Your Ref: OWPC14606
Our Ref: BR/194/17/PL 30-06-2017
Please ask for:
Richard Temple

Demolition of the existing Foreshore office and decommissioning of existing underground toilets. New purpose built unisex toilet block including urinals, baby changing facilities and accessible WC, plus a separate beach office with public information point and first aid facilities. All located on the existing seafront promenade.

Promenade Opposite Clarence Road The Esplanade Bognor Regis

Thank you for your internet representation made on 18th July 2017 which has been recorded as '**an objection**' with the comments as follows:

DRAWING
Proposed Toilet Elevations

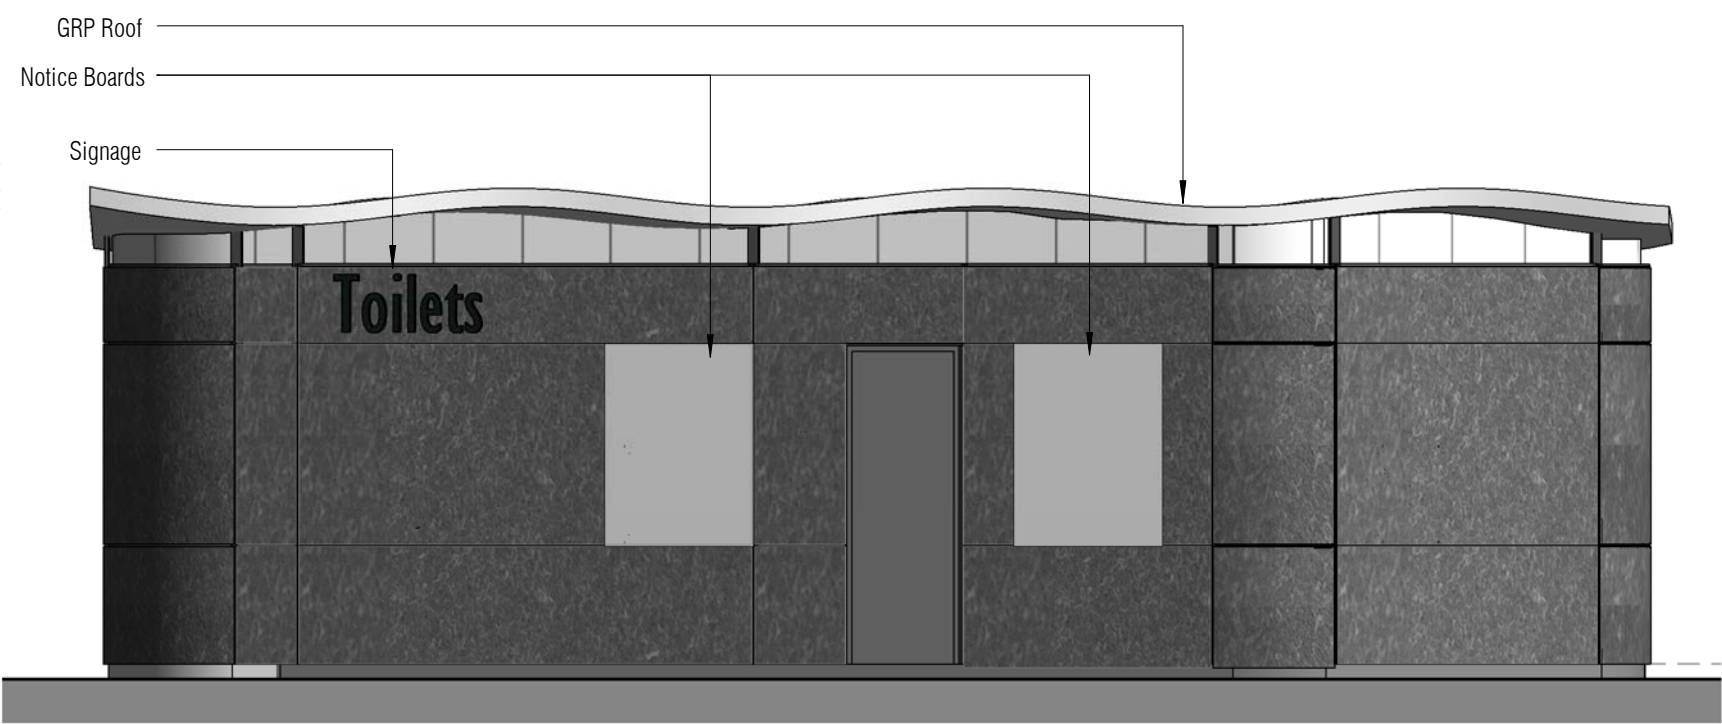
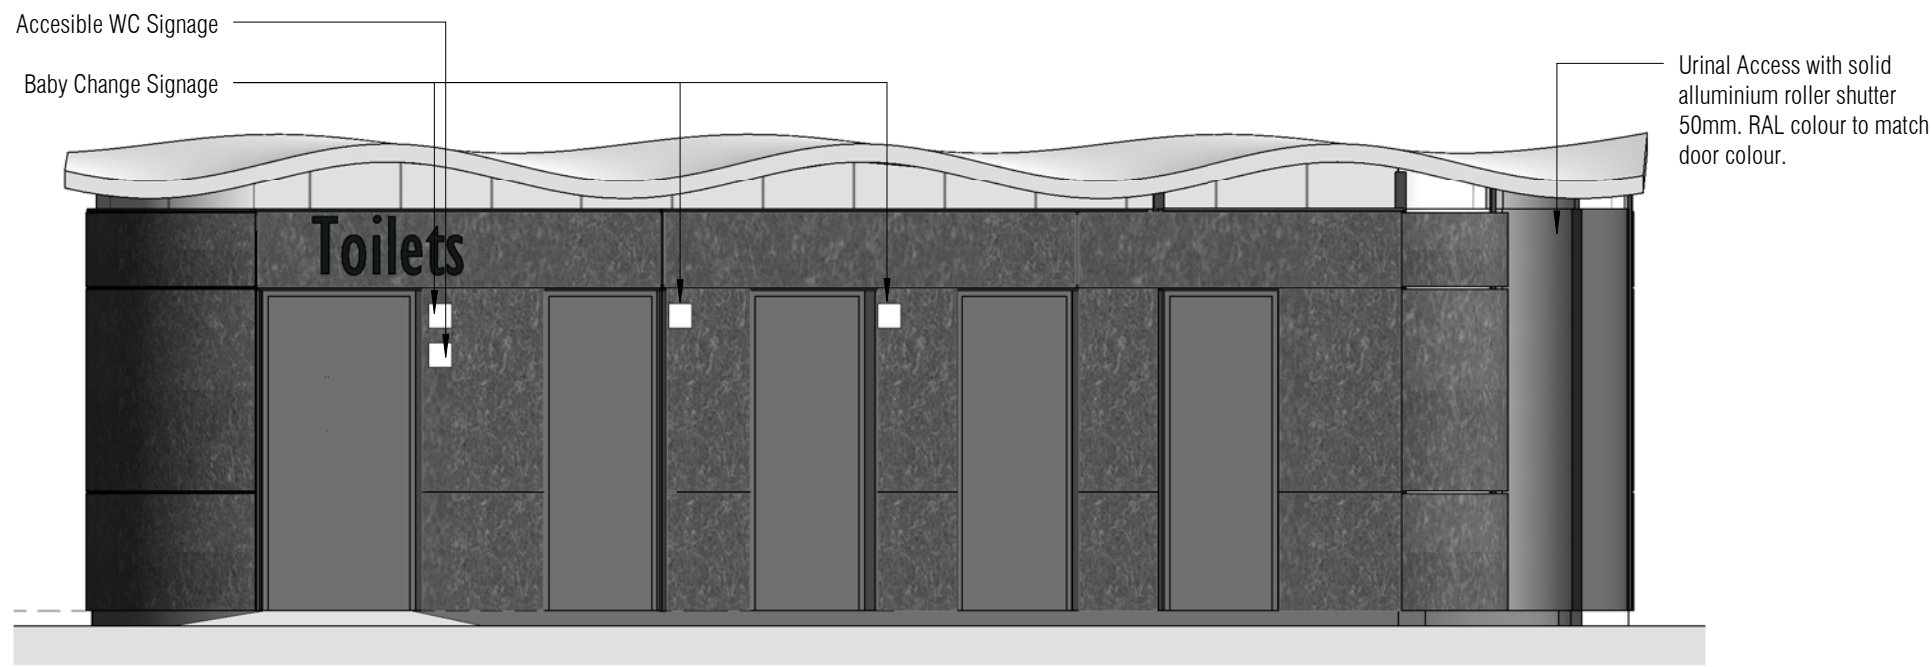
Toilet Door Position. To have the cubicle doors on the north side is outrageous and unacceptable for what concerns aesthetics. To have toilet in/out/queuing activity in front of their eyes all day long would be absolutely disgusting and intolerable to residents in the buildings opposite. Such an orientation of the doors runs completely contrary to civilised values, to the point of vulgarity, and takes no account whatsoever of the human factors of the surrounding locality. In my opinion, this aspect alone negates the validity of the whole proposal.

- i) Locate the new facilities to the west of Whittington's kiosk/shop/train-garage, clear of the train turning circle - i.e. to the current location of the deckchair hire kiosk. Any need for additional water/waste/electrical connections would not be adequate reason to preclude this solution.*
- ii) Position the toilet cubicle doors on the south side.*
